From:
Sent: 30 July 2024 20:55
To: DCAdmin
Subject: Planning application 2024/91316

In response to the planning application to build 17 dwellings on 236 Leeds Road I have two points to raise:

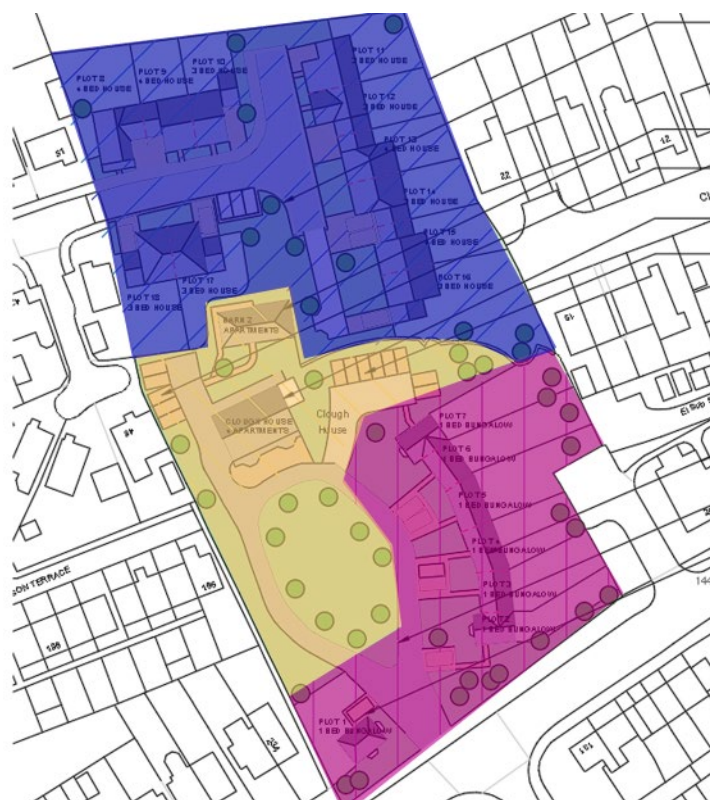
It isn't clear from any of the plans and drawings how the new buildings are placed in relation to existing properties, however, on page 7 on the "design and access statement" document number 1040951 it clearly shows on page 7 the properties at plots 7, 8 and 9 are set a lot further forward than the existing properties.

This will impact the existing properties on the same side of the street in that the view when getting off their drives will be blocked by the new houses hiding any vehicles coming from them. Surely the new houses need to run along the same line?
